**Consultation Response from KC,
Lead Local Flood Authority**

2023/92278 507A, Bradford Road, Batley, WF17 8LL

Formation of two additional floors and creation of six trade counter units within existing building and external alterations to existing brick clad portal framed industrial unit (within a Conservation Area)

Date Responded: 29TH October 2023

Block Plan 1: 200

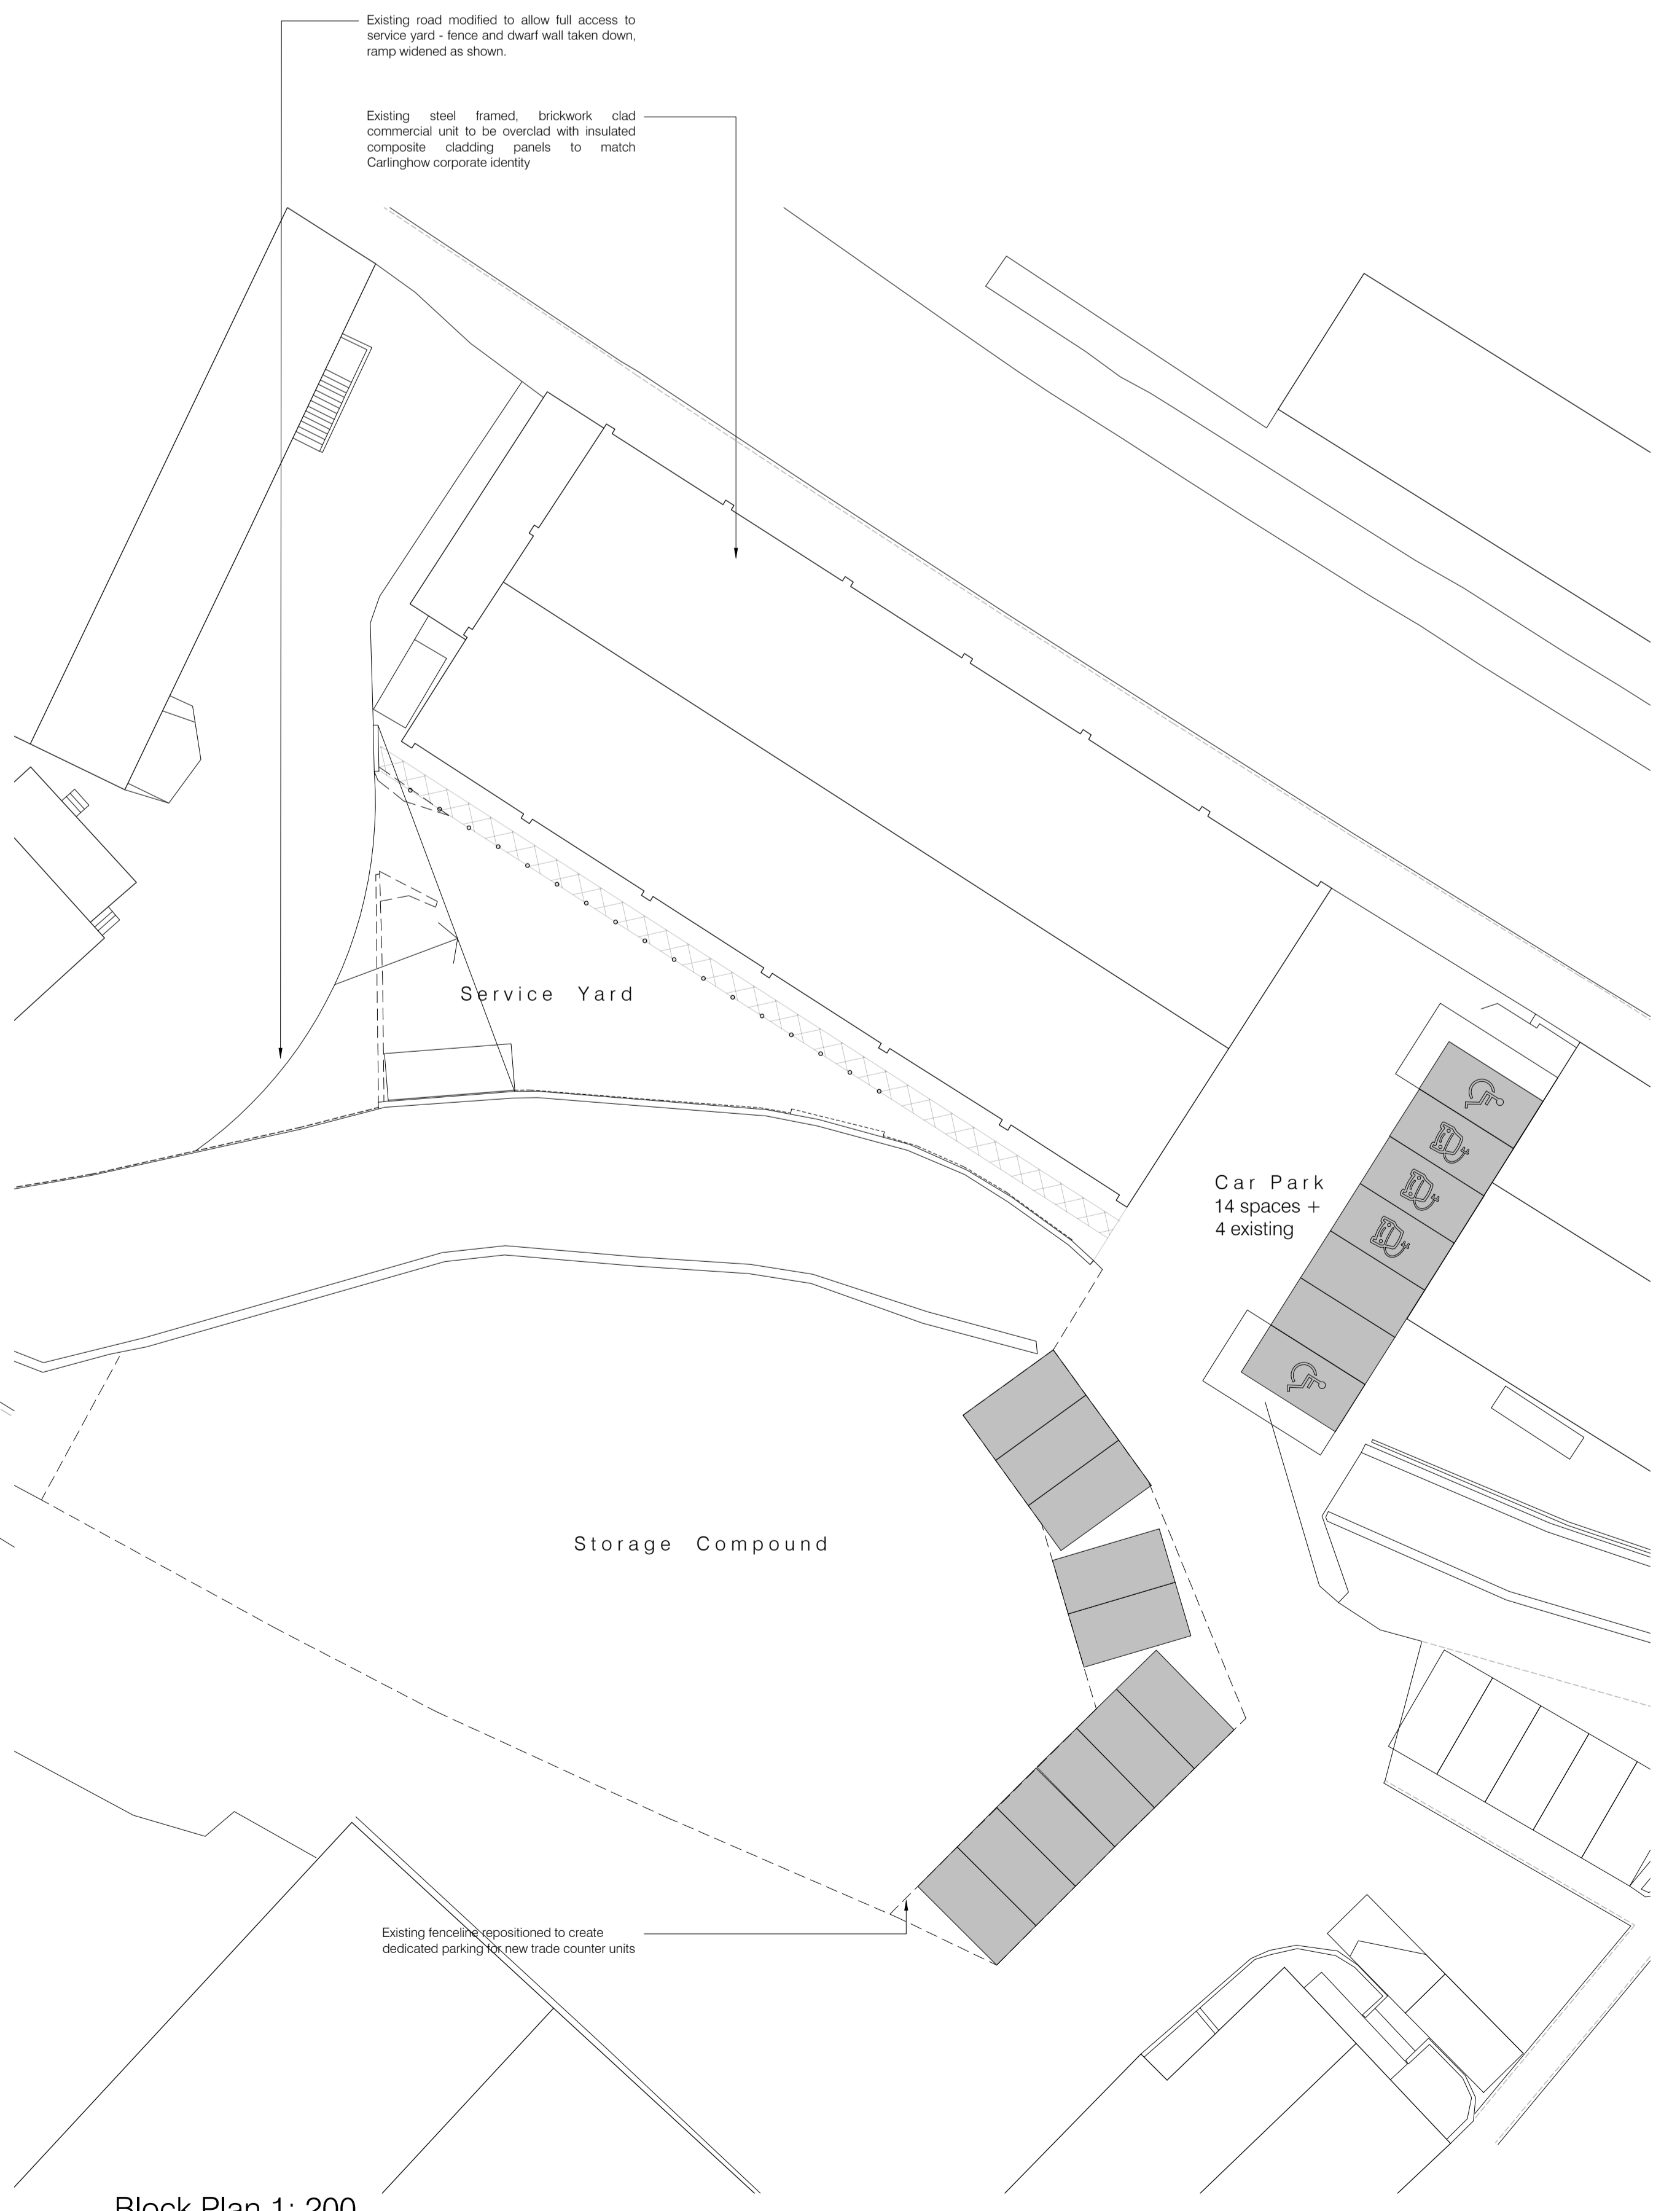
Clarification is required on the current drainage for the parking area and whether there are positive drainage connections to watercourse or sewer. This will form the basis of discharge requirements set for the proposed parking area if the surface is to change.
